Re: Proposed development N70 Waterville to Ballybrack Road Improvement Scheme
Townlands of Waterville, Ballybrack and Eightercua, Co. Kerry

Re: Application of Kerry Council for Consent for Proposed Development (N70 Waterville to Ballybrack Road Improvement Scheme) – Our Clients Barry & Bernice O'Donovan, 5 Benjamin Close, Ballybrack, Waterville, Co. Kerry

PROPOSED N70 WATERVILLE TO BALLYBRACK ROAD IMPROVEMENT SCHEME

Submission made on Behalf of
Barry & Bernice O'Donovan,
5 Benjamin Close, Ballybrack

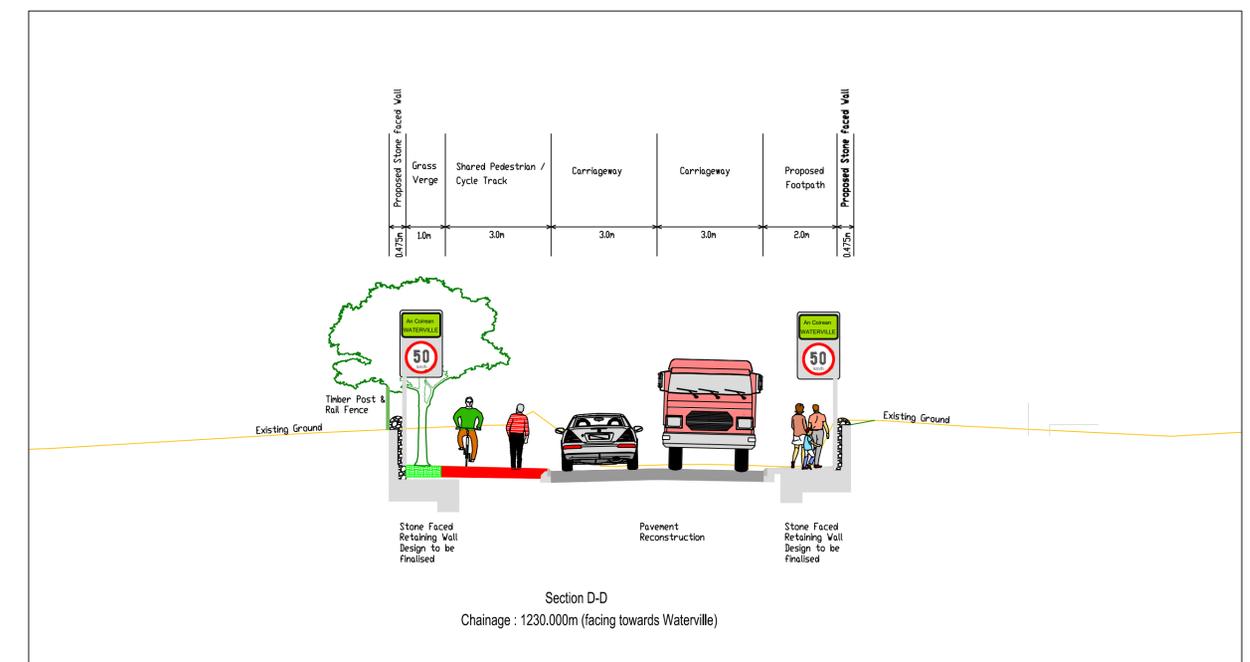
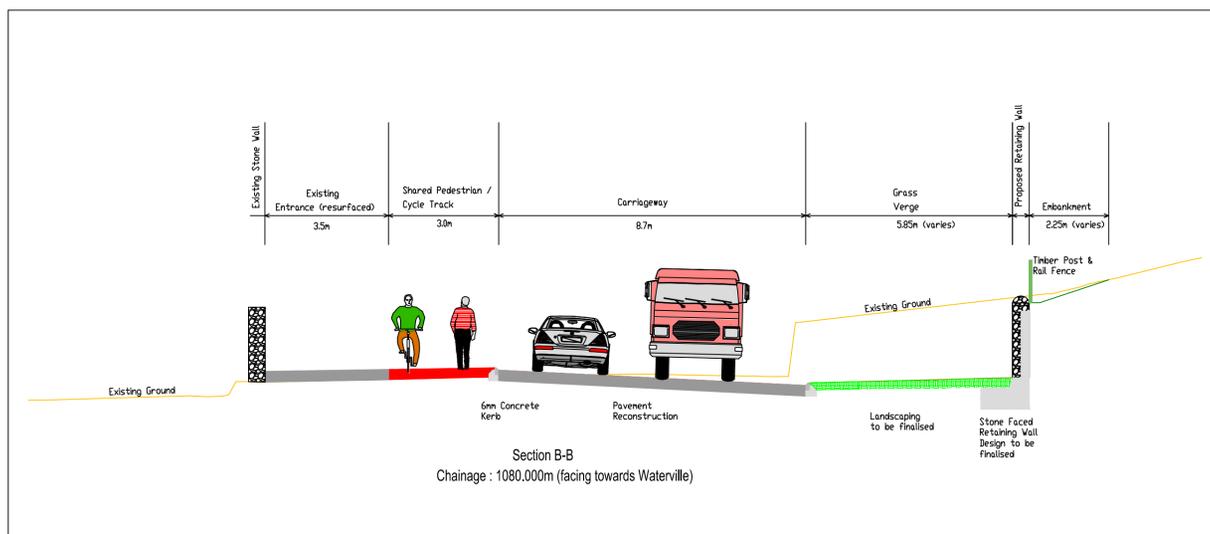
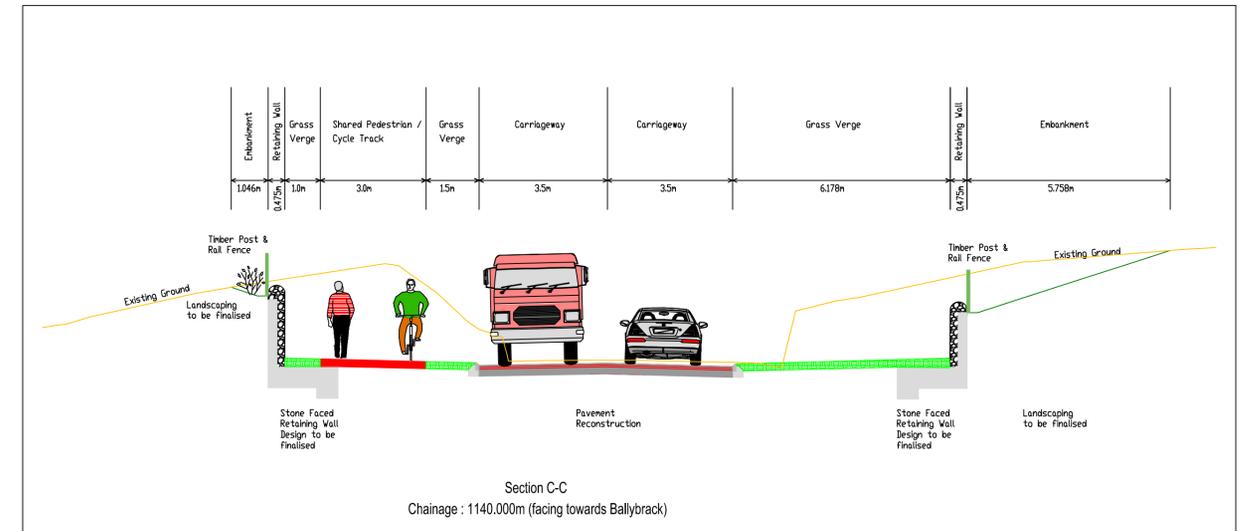
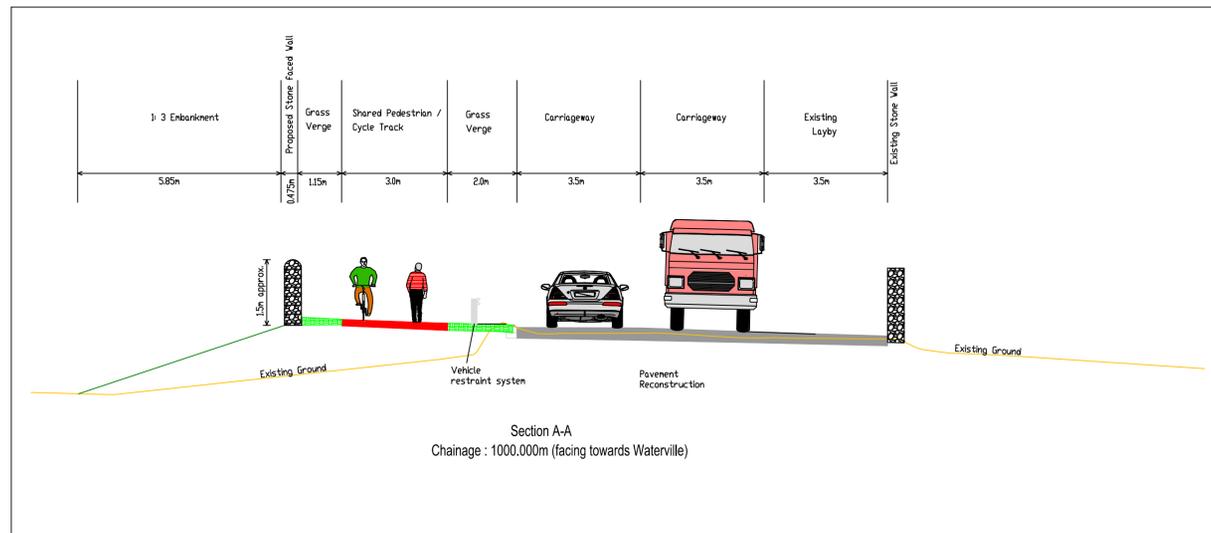
3.2: Shown overleaf is the Cross-sectional Detail as published for Ch 260m – i.e. at the centre of our clients’ property. It is understood that the vertical scale is, as would be normal in these cases, exaggerated, but there are some inaccuracies (or at the very least simplifications) in the Sections, not least in respect of the representation of the existing roadside ditch, which is both higher and wider than shown, but the position nonetheless shows what will be a very unacceptable picture for our clients

While the centre level of the road here is to be maintained, the revised camber suggested will raise the road edge by c. 100mm, and more significantly, the level immediately inside the existing ditch is shown as raised by 600mm+, and worse, rises further from there to the inner edge of the proposed “take”, and, worst of all, filling in, as it does so, the “Swale” at the lowest point of our Clients land. While it is unlikely that the levels can be altered significantly from those proposed, it is very much the case that the levels of accuracy & of detail of the existing and proposed levels required to properly illustrate the effects on our clients property are missing, and that the reality of the detrimental effect of the alteration of relationship between our the levels of clients’ lawn and the road is not fully illustrated.

3.3: What is however very obvious from the proposed section is that the section of our clients’ lawn near to the road slopes significantly towards the road, and that the proposed “take” removes the lowest end of that slope. As will be illustrated later, the soakage/percolation here is poor, and the surface water drainage opportunities very limited. For further discussion on this, see “Drainage Issues” below.

Title: **Fencing, Walls and VRS Sheet 01 of 02**

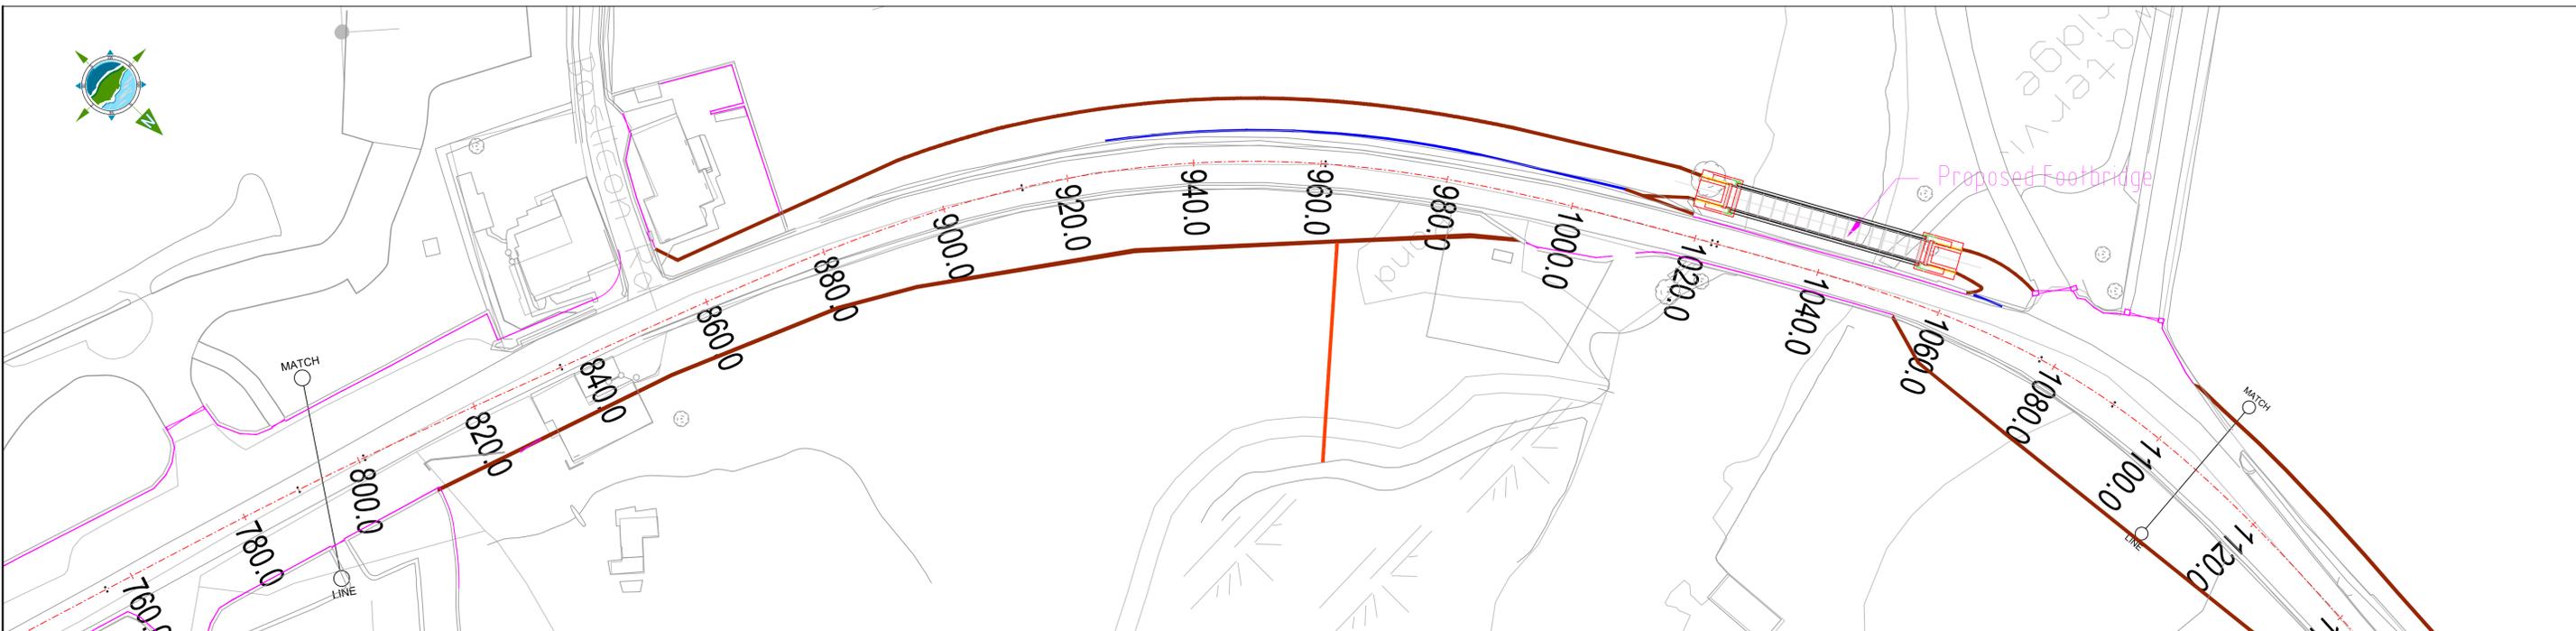
6.1: The existing roadside boundary structure is a stone & slightly sodded construction. Our Clients have, over the years, cleaned it down and made both the internal and external faces a feature of their garden- see above, this despite the difficulty of working safely on the roadside face.

They would require that any replacement wall be of similar construction – not just the standard stone-faced blockwork. This is in part to maintain the character of their boundary, but is also in recognition of the heritage of the area, and with particular reference to the Megalithic Monument known as the Eightercua Stone Row, which is situated less than 350m. away.

6.2: Also, the existing ditch, while shown on the sections as only 600 mm high, is actually 1000 - 1200 mm high over the road level. Our Clients would require that any replacement be 1200 mm high over road level. This would more closely reflect the existing position, but the increased pedestrian & cycle traffic that will result from the proposal is also a factor to be taken into account.

6.3: As illustrated in the Section at 5.1 above, the thickness of such a wall will also be a factor in determining the exact land take required, and the Council may need to put some further thought into this, not least as the new structure will also, if only to a limited degree, have to provide some retention capability, given the difference in levels.

6.4: Our clients have a particular requirement to both contain and exclude animals within and from their property, and in consequence have erected a post & wire fence on top of all of their boundary walls, including that to the road (see photo, Right). Any new roadside boundary wall would need to have a similar fence incorporated.
